Application no: H08/0345/01

Description: Ground and first floor extension. Provide pitch roof to existing building

Location: Allendale
Beck Bank
Gosberton Clough
Spalding

TOWN AND COUNTRY PLANNING ACT 1990
NOTICE OF ACCEPTANCE OF AMENDMENT

SOUTH HOLLAND DC
 HOUSING & PLANNING
 18 AUG 2001
 Ref: 345601

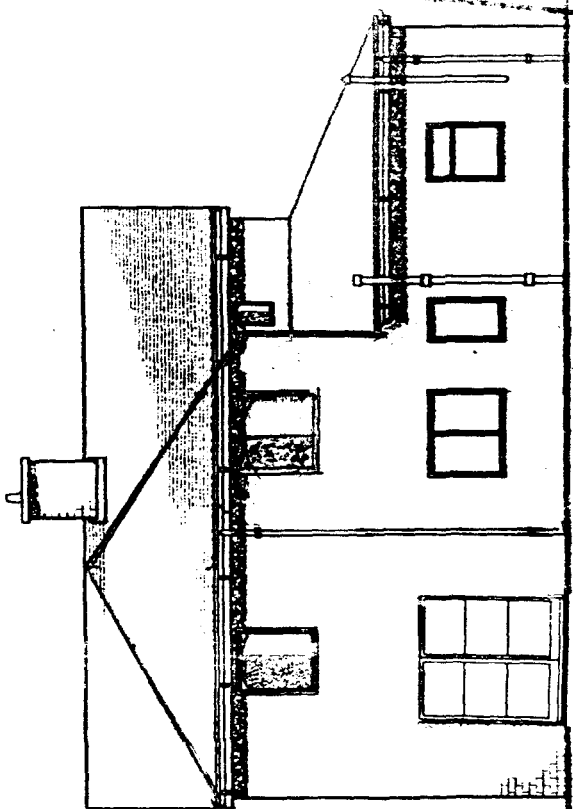
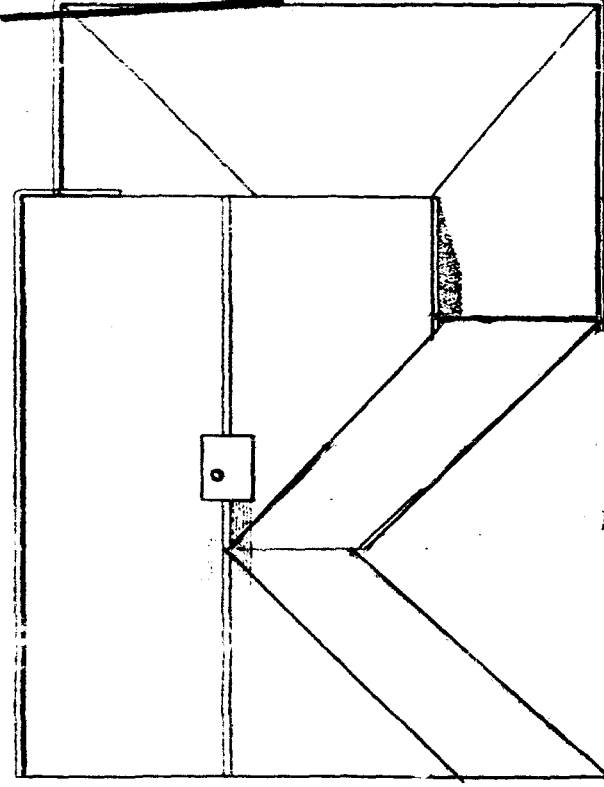
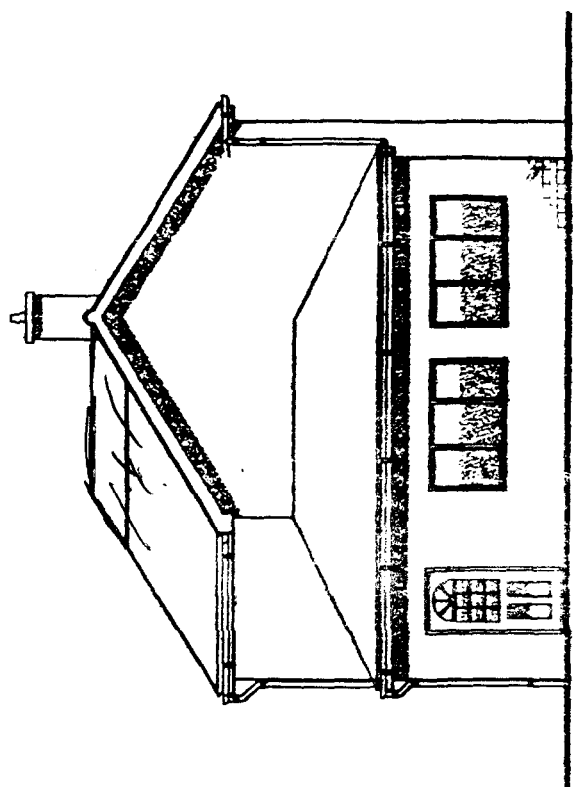
Amendment: Increase extension 2.4 metres southwards at 1st floor.

~~Extend~~ Increase extension 2.4m Southwards at 1st floor.
SEE ATTACHED
LETTER + PLAN.

As you can see this would involve the scope of work extending over the existing bathroom. I am aware this is possibly more than a normal request for an amendment, however I would like you to consider my request for the following reasons.

The amended details submitted in respect of the above proposal have now been considered and there are no objections to the amendment being implemented to the extent described above.

Extn ^{opposite} on side of original proposal to Westdale.
ridge rises by about 0.5m but Westdale 11 metres
away. Do not consider amendment materially
effects Westdale not significantly different to that
which received PR.

NT02/202

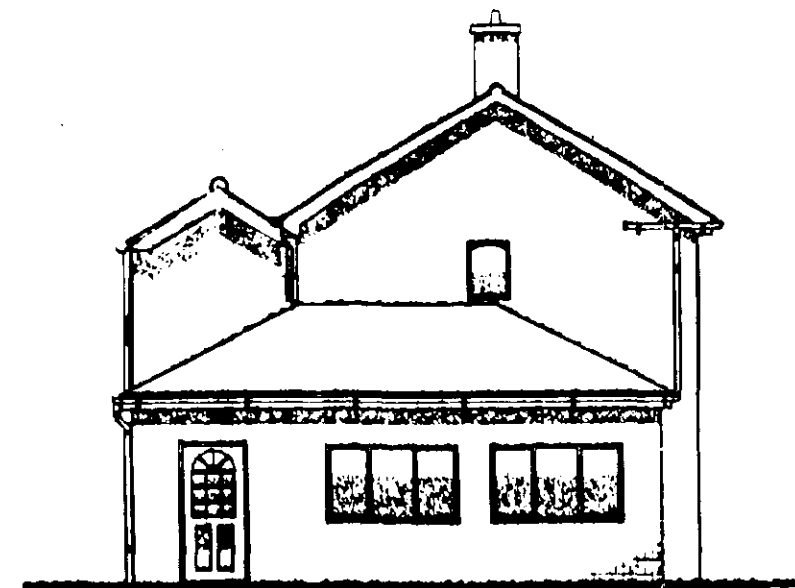
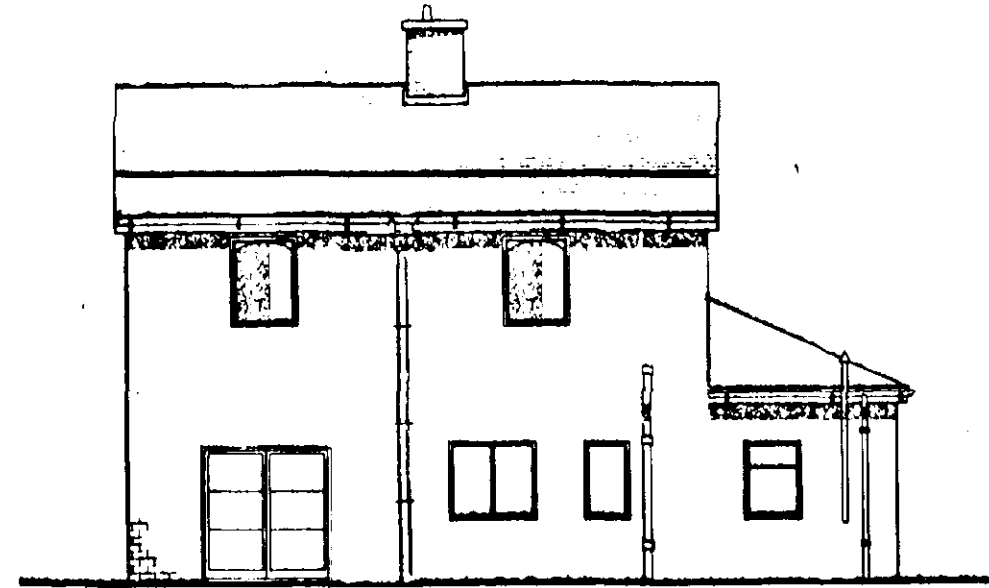
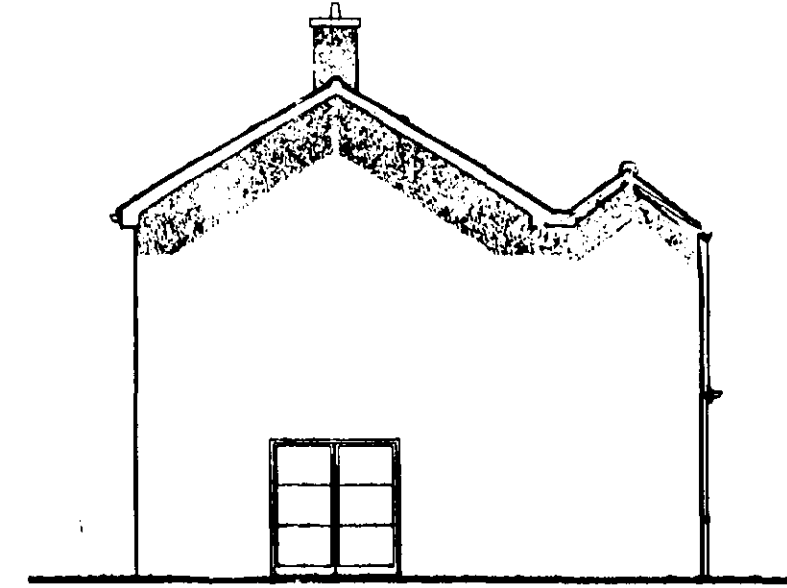
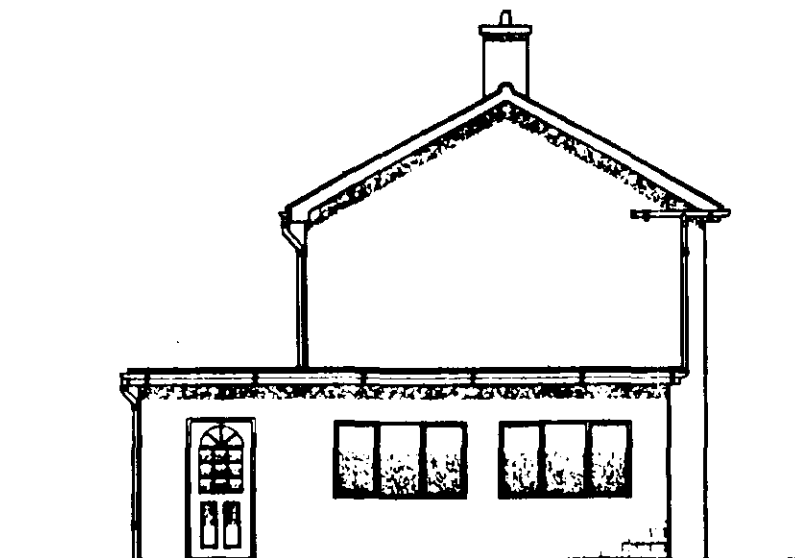
Amendment: Roof on extension amended from hipped to double gable. Dwg.No.NT021202

To alter roof of extension from hipred type to double gable to bring building in line with existing See DWG, NT 021202

The amended details submitted in respect of the above proposal have now been considered and there are no objections to the amendment being implemented to the extent described above.
